COUNTY COUNCIL'S RESPONSE TO CONSULTATION ON THE FOLLOWING DEVELOPMENT PROPOSAL

Application No: 21/01119/OUT

Proposal: Outline planning application for the re-development of the Banbury Oil Depot to include the demolition/removal of buildings and other structures associated with the oil depot use and the erection of up to 143 apartments and up to 166m² of community and/or retail and/or commercial space (Class Use E and/or F2) with all matters (relating to appearance landscaping, scale and layout) reserved except for access off Tramway Road

Location: Q8 Fuelcare, Tramway Road, Banbury

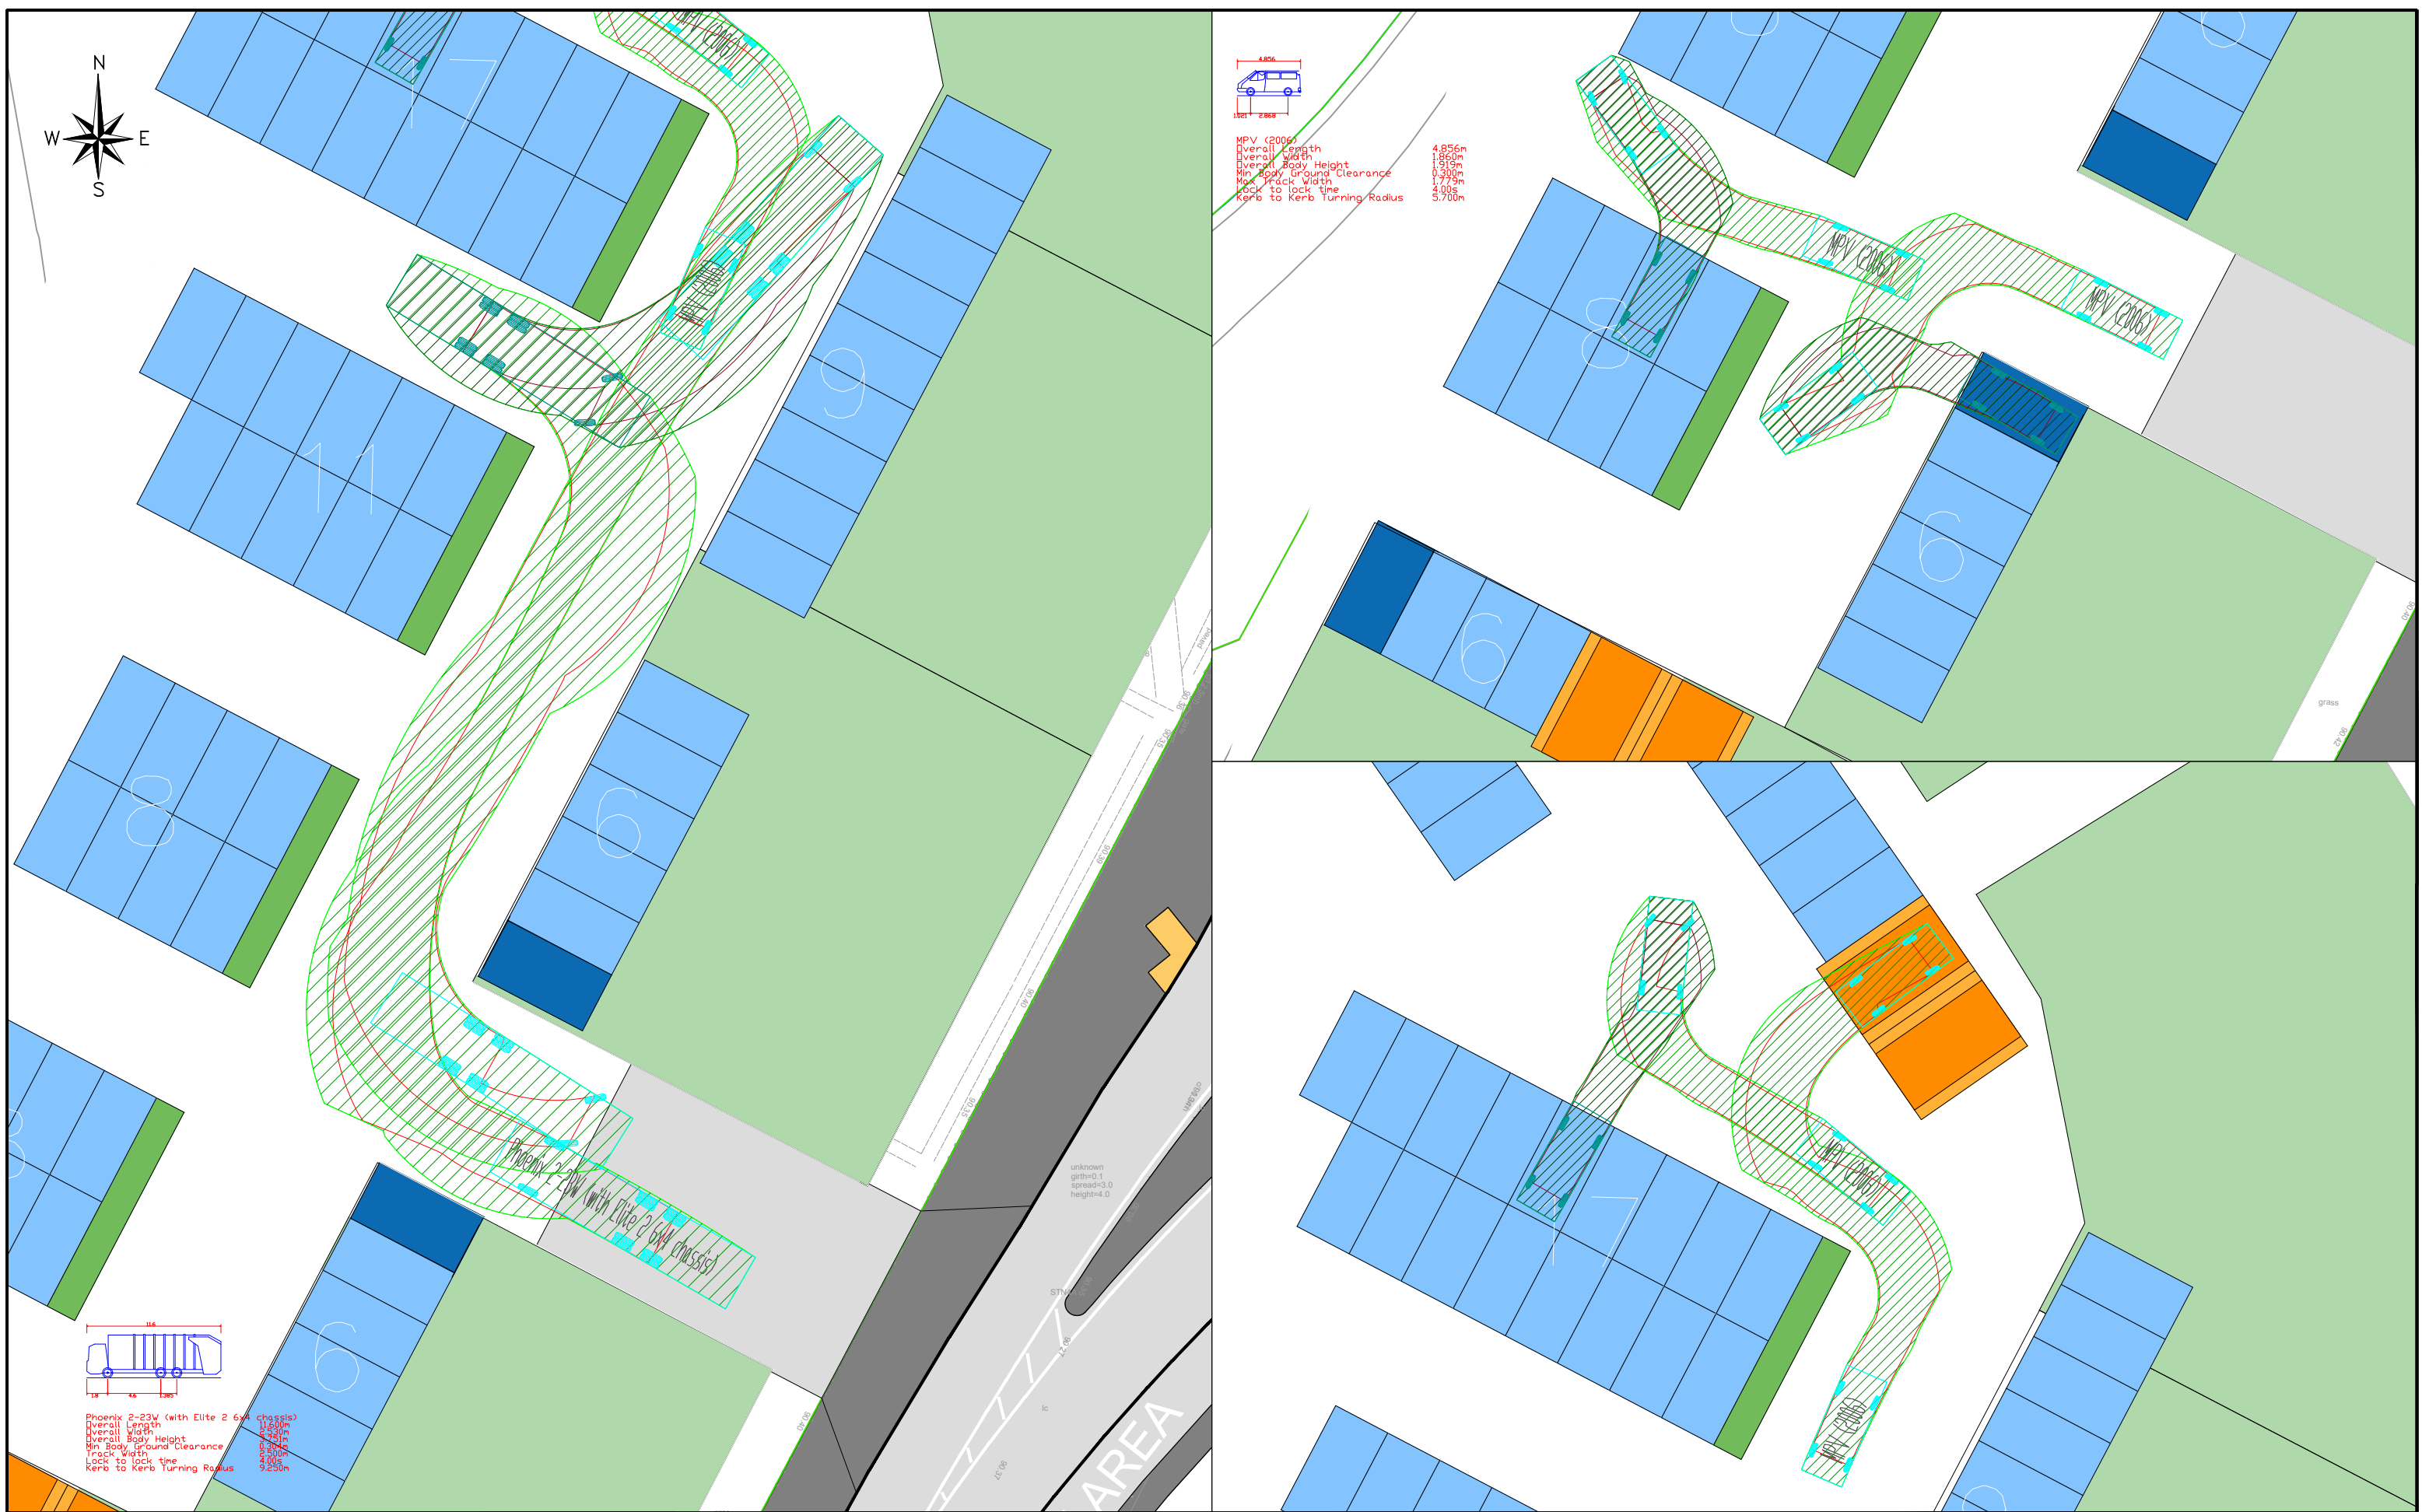
Access- The site access is off Tramway Road, a 6m single carriageway width road with two-way traffic for vehicles including footways on both sides of the carriageway with a speed limit of 30mph. A continuous footway network runs alongside Tramway Road and connects into Banbury Town Centre. The footway also gives access to the canal towpath. Vehicular, pedestrian and cycle access will be via Tramway Road. There are two potential access arrangements, the first proposes a standard bellmouth arrangement as shown on Drawing 22251-02. The alternative would be a shared surface footway crossover which gives priority to users of the footway/ cycleway that is proposed past the site as shown on Drawing 22251-02-1. The internal layout has also been tracked with a large car and a Refuse vehicle which can be seen in Drawing 22251-02-2

OCC require a swept path analysis for an 11.6m in length refuse vehicle for all manoeuvres in forward gear passing an on-coming or parked family car throughout the layout. The swept path does not indicate how an oncoming or parked car and evidence will be required if this layout is to be adopted. The carriageway will also

require widening on the bends as indicated in the OCC Residential Design Guide Second Edition (2015) Para 6.28.

- The access should prioritise north/south movements by users of the footway/cycleway so this should be a raised access.
- The current arrangement would be unlikely to enable vehicles to turn left out of the access, radii should be suitable for this and tracking undertaken acknowledging the Tramway Road scheme provided (6m radii).
- Appropriate visibility splays should be shown and maintained.
